## Appendix - Sunnica Arb comments

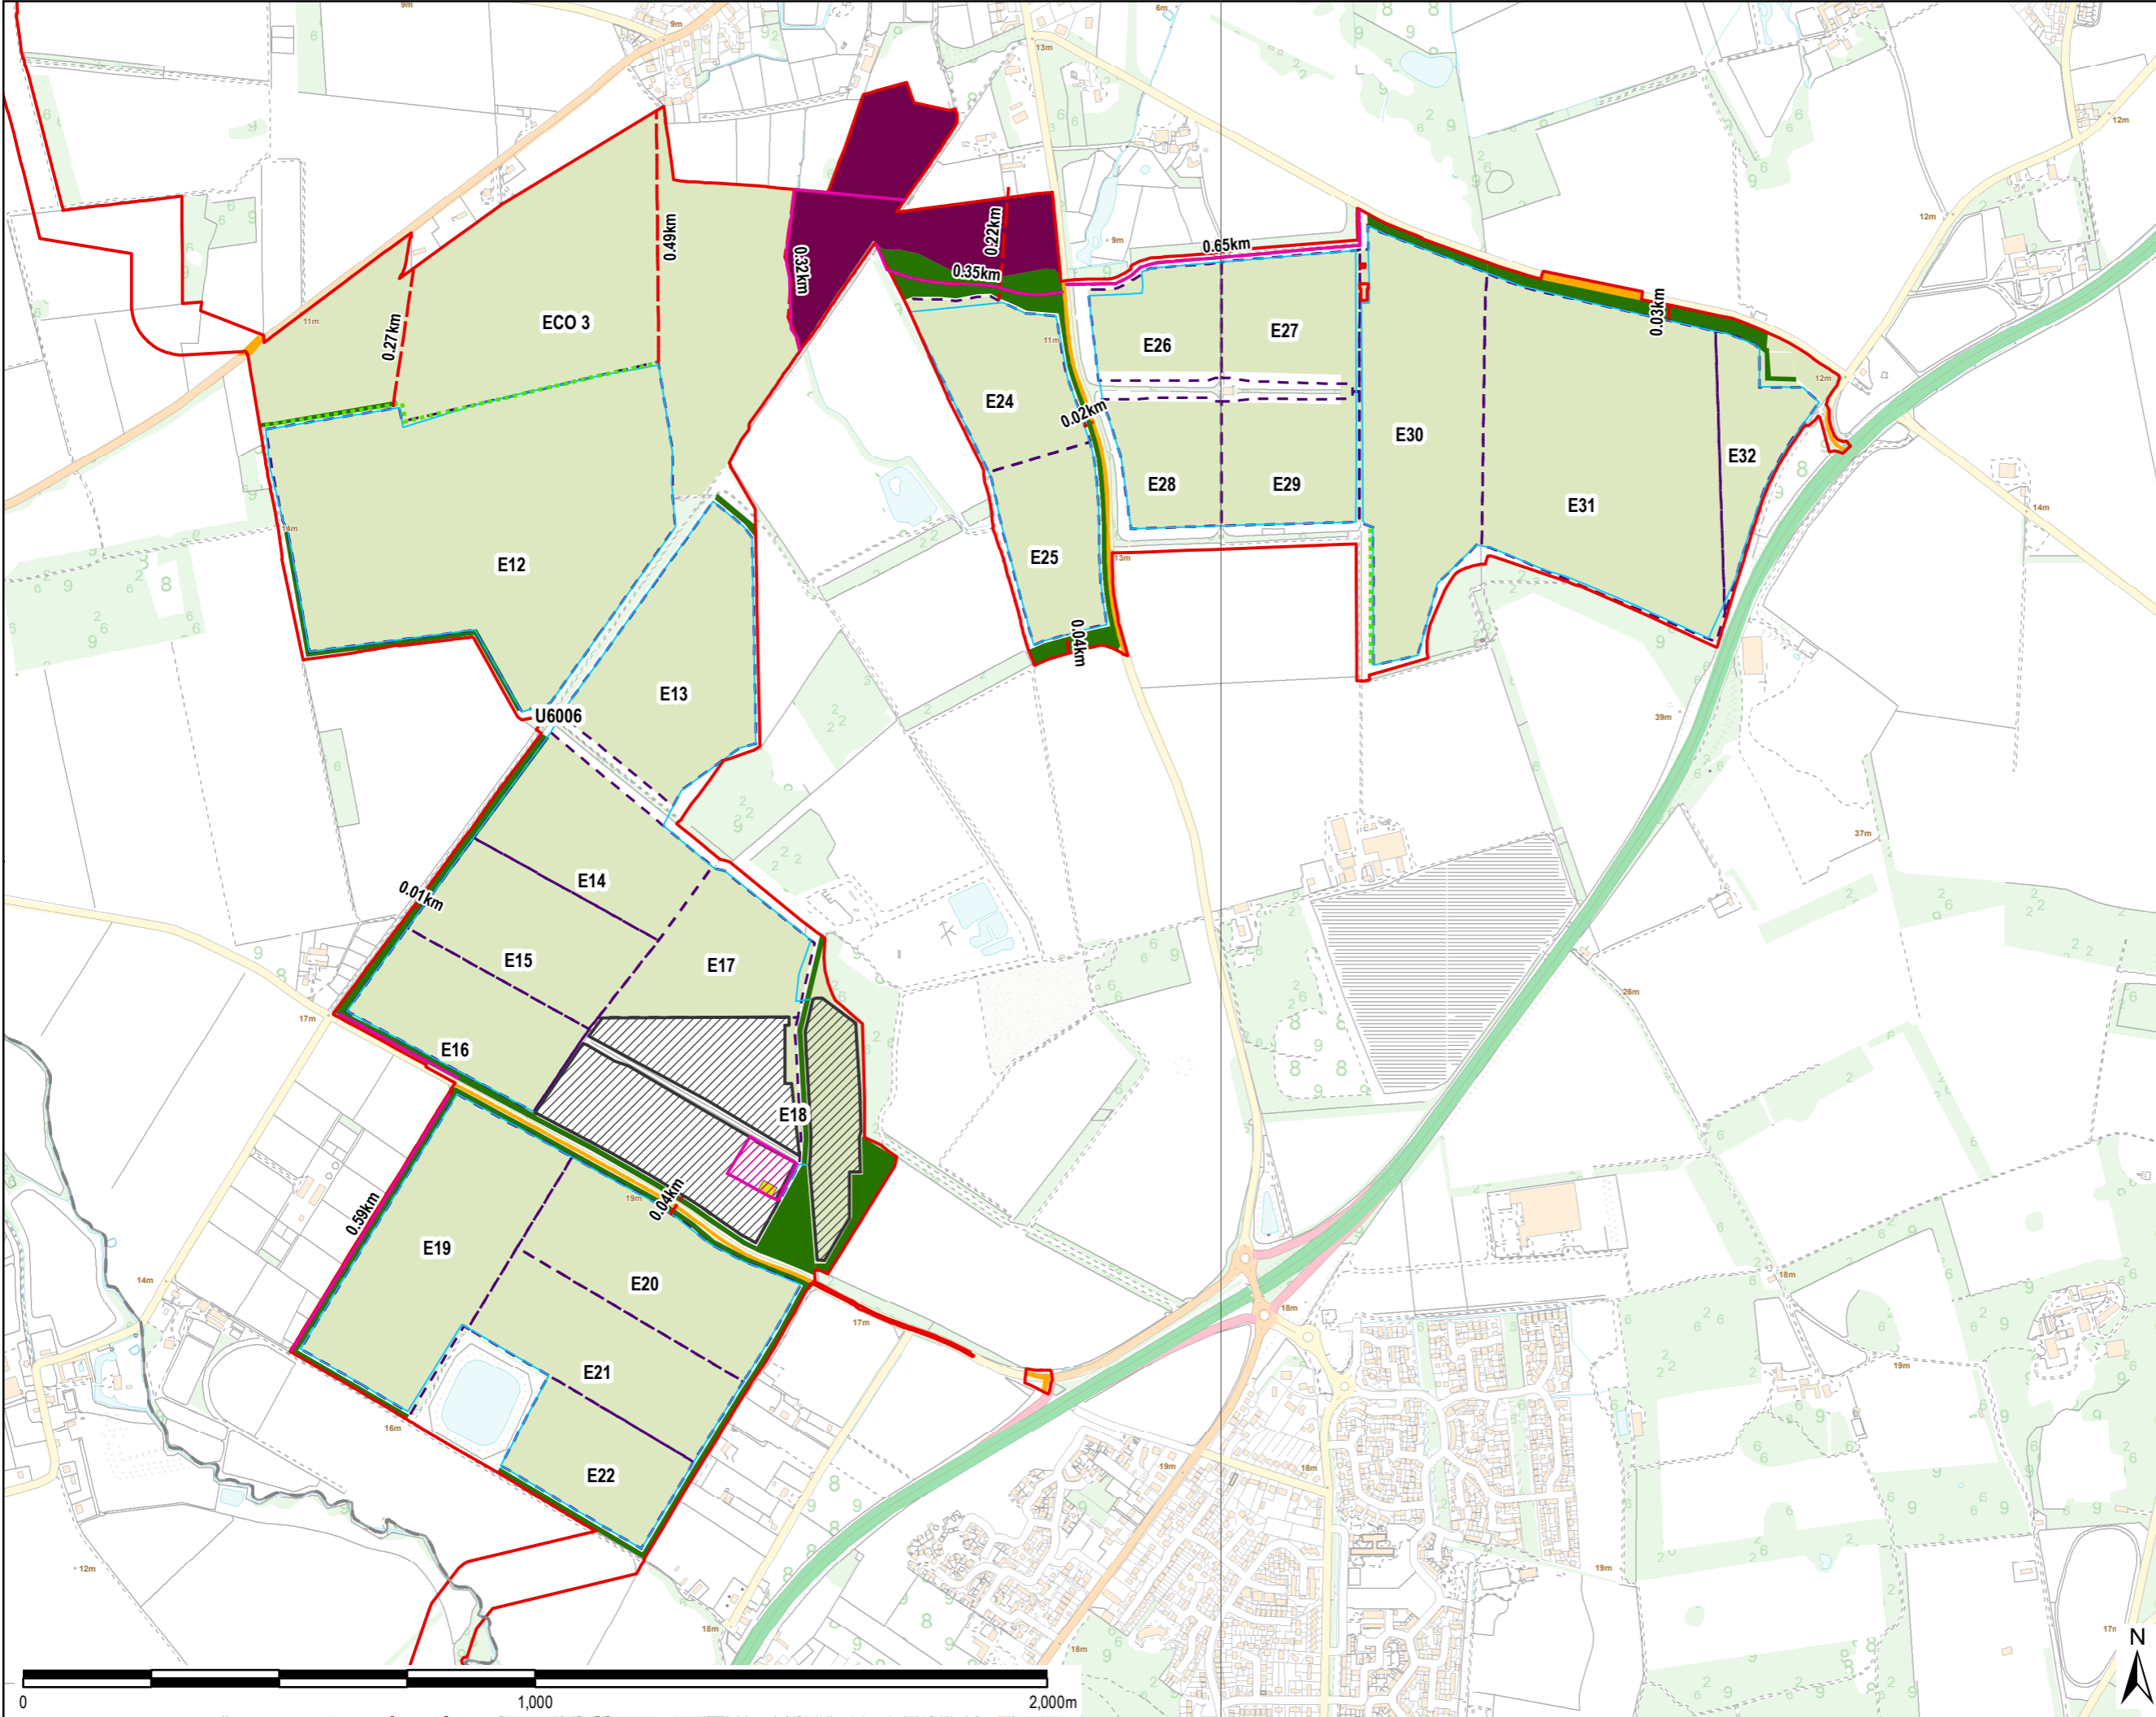
Although the AIA report states that the Chippenham Park avenue will not suffer tree losses the environmental master plan still shows that there will be some losses which is correct and how can the potential impacts of this development be accurately assessed or managed when the information provided by the applicant doesn't align with itself.
